<b>REQUEST</b>	Current Zoning: <del>R-3</del> (LLWPA), R-9MF (CD)(LLWPA), and <del>R-17MF</del> (LLWPA), single family residential Lower Lake Wylie Protected Area, multi-family residential conditional Lower Lake Wylie Protected Area, and multi-family Lower Lake Wylie Protected Area. Proposed Zoning: INST(CD)(LLWPA), institutional conditional Lower Lake Wylie Protected Area
<b>LOCATION</b>	Approximately 9.05 acres located on the east side of Toddville Road between Paw Creek Road and Freedom Drive.
<b>CENTER, CORRIDOR OR WEDGE</b>	Wedge
<b>SUMMARY OF PETITION</b>	This petition proposes to allow a 65,000 square foot expansion of an existing nursing facility. This facility will add <del>60</del> <sup>sixty</sup> new beds bringing the overall total of the site to 180 beds.
<b>STAFF RECOMMENDATION</b>	Staff recommends approval of this petition upon resolution of outstanding issues. The petition is consistent with the <i>Northwest District Plan</i> .

<b>Property Owner</b>	Charlotte Health Care Center, Inc and Medical Facilities of America LXVII Limited Partnership
<b>Petitioner Agent/Representative</b>	Medical Facilities of North Carolina, Inc Collin Brown
<b>Community Meeting</b>	Meetin

**TECHNICAL DATA SHEET**

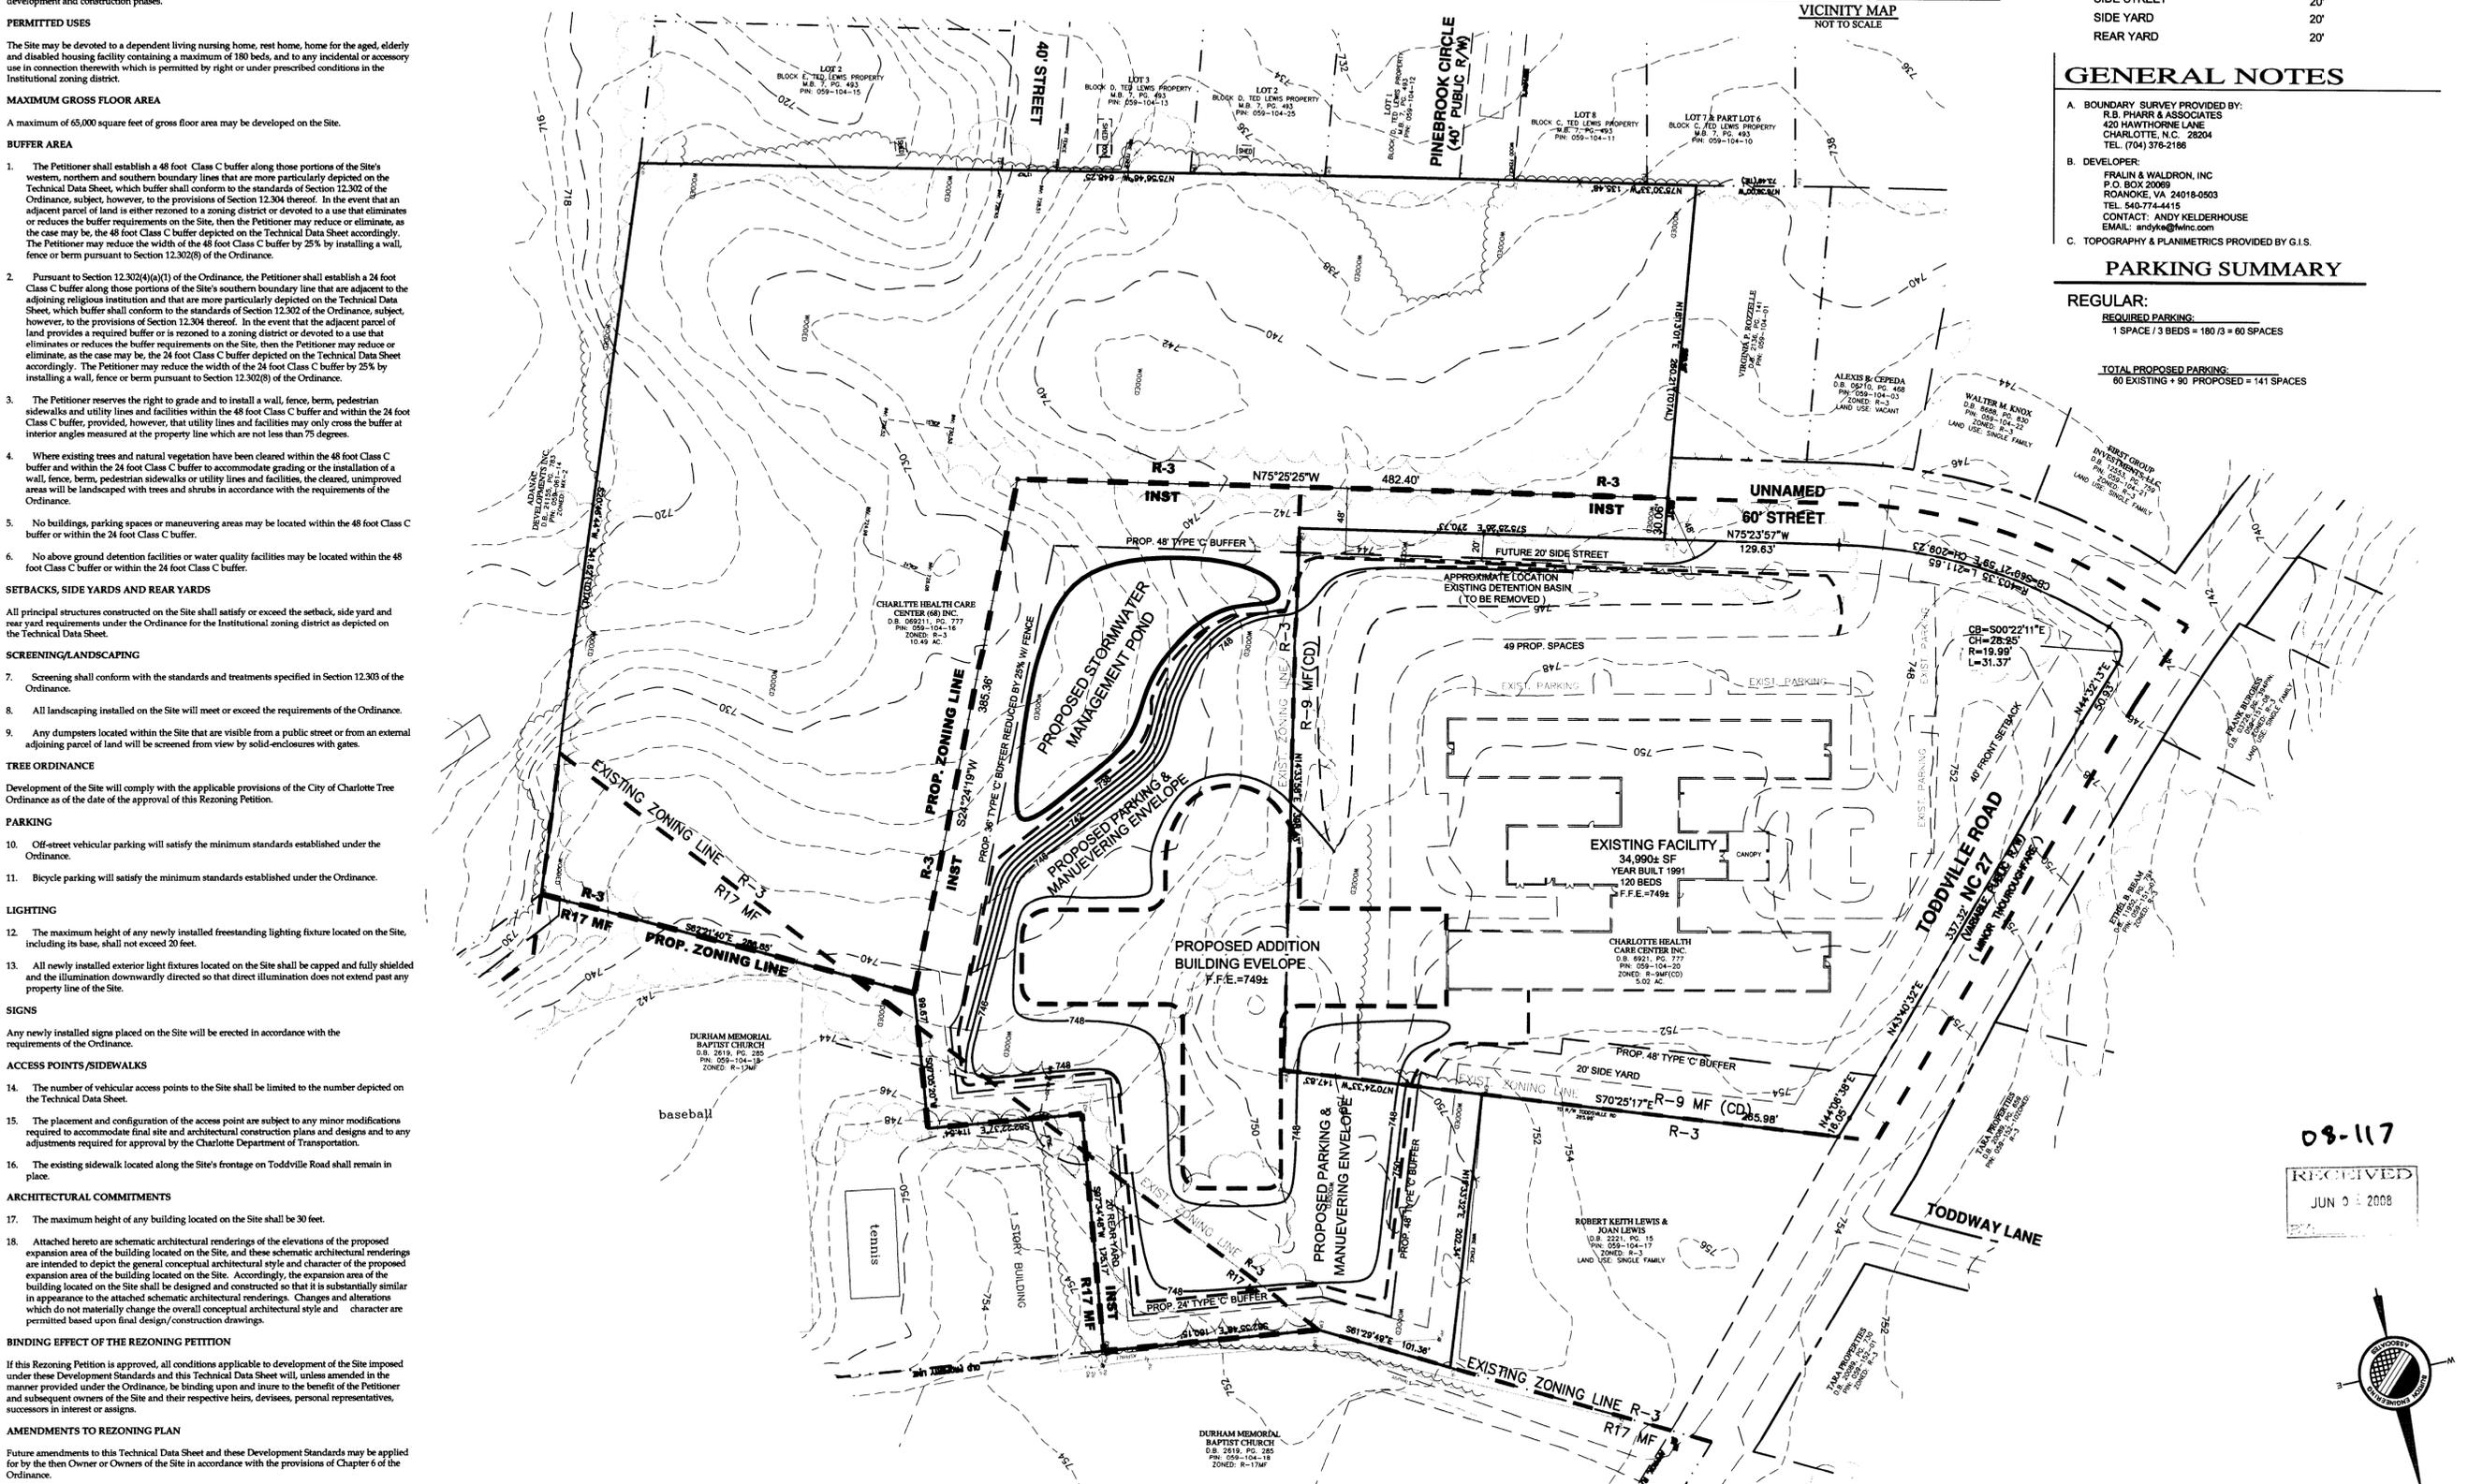
1. Clearly delineate the boundaries of the rezoning in a heavy dark line on the site plan. Show that Lot 2 is not included in the proposed rezoning.
  2. Show the north side of the property at the top of the page.

3. Amend Note #2 to indicate that a 24-foot buffer will be provided along those portions of the site's "northern boundary line that are adjacent to the adjoining religious institution".

4. Amend Notes # 3 and #4 to reflect that only "required" sidewalks are permitted in the buffer and to eliminate the use of a berm to reduce the buffer width.

5. Amend Notes #5 and #6 to indicate that parking, maneuvering and detention/water quality facilities may not be located within any buffer or setback.

6. Revise the site plan to reflect dedication of the right-of-way for the unnamed 60-foot street along the site's southern boundary if the right-of-way has not been dedicated[[twk1](#)].

7. Show and label all sidewalk widths.
  8. Submit elevations, as referenced in Note # 22.
  9. Provide a minimum five foot sidewalk and eight foot planting strip along all street frontages.

10. Add a note that the petitioner will submit a Solid Waste Management Plan prior to initiating land clearing, demolition and/ or construction activities.

11. Add a note that the unnamed public street will be constructed to the office/ commercial narrow street cross section.
  12. Reflect proposed zoning as Institutional CD.
-
